RE: Hyak Amended Planned Unit Development Final Development Plan Addendum

As a result of meeting with you and staff reviewing the CDS Letter dated January 19, 2018, we would like to add this addendum to the original Hyak Amended Planned Unit Development (PUD) Final Development Plan submittal. Please accept this narrative, in accordance with your letter dated January 19, 2018 meeting the requirements in order to obtain final development plan approval.

HYAK SNOW STORAGE EXHIBIT

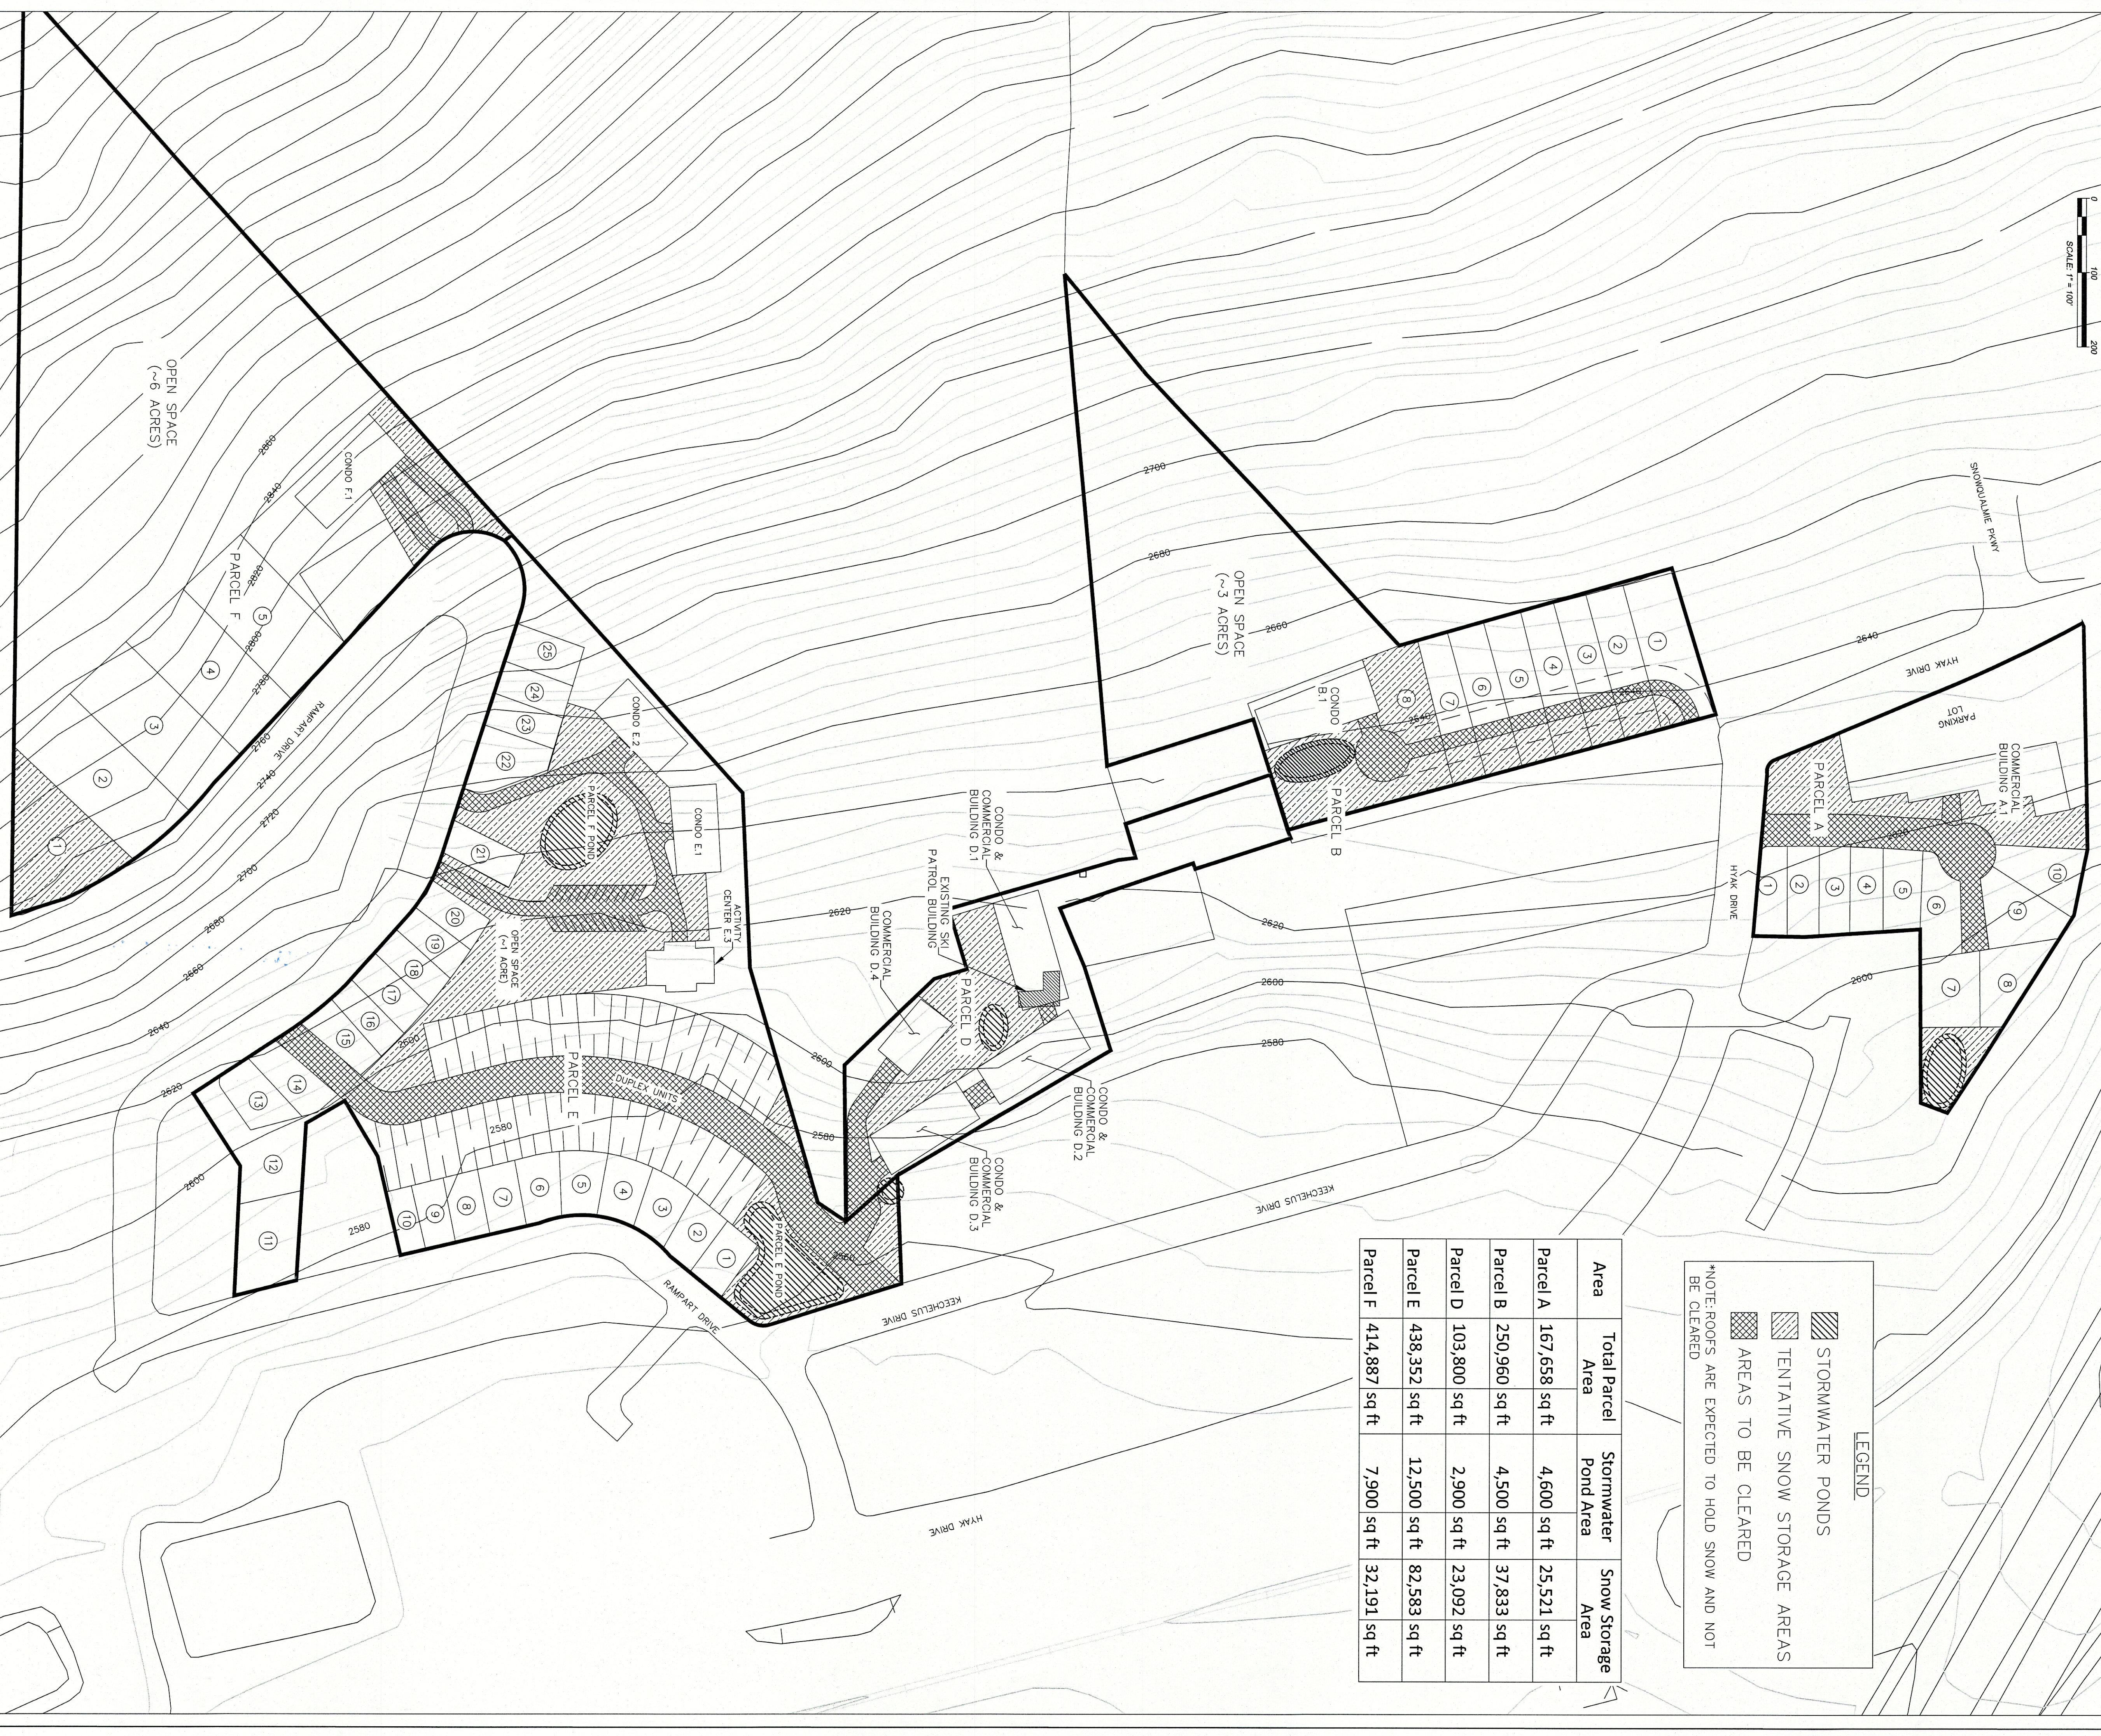
Section A.2, viii. Pubic works memo calls stormwater out as a potential issue, for the purpose of the FDP applicant shall provide a conceptual stormwater plan with shall include detailed contour information. Using strowmater facilities for snow storage are also a concern.

Response: We have included the contour information and overlaid onto the larger scale maps providing more detailed information per the Kittitas County Department of Public Works memo. It is also understood that this initial proposal is for final development plan approval and once final divisions are proposed then a detailed stormwater design/plan will be submitted for review and approval including but not limited to snow storage scenarios. See Addendum Attachment A & B.

Generalized Lot Drawing
Specific Definitions On Attached Document

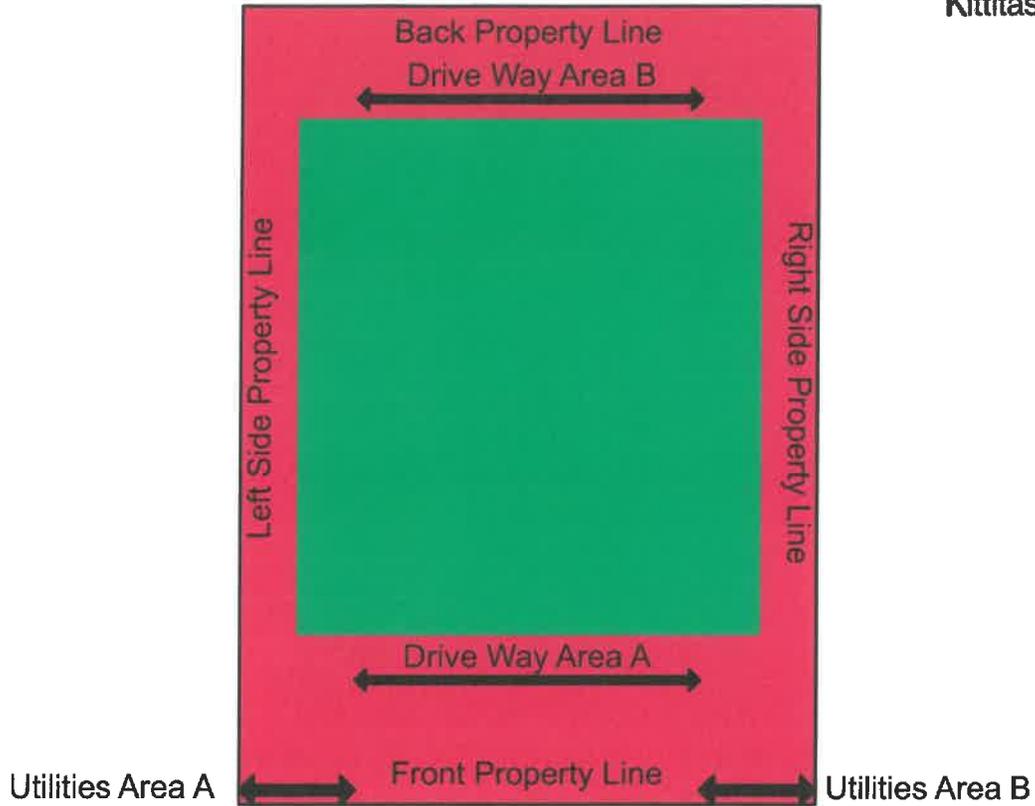
Section B.5 Applicant shall update narrative and amend lot drawing to identify conditioned setbacks.

Response: The required setbacks are as follows: Front yard setback of 25 feet, Side yard setback of 10 feet, and Rear yard setback of 15 feet. We have included an updated lot-drawing map that contains the required setbacks. See Addendum Attachment C.
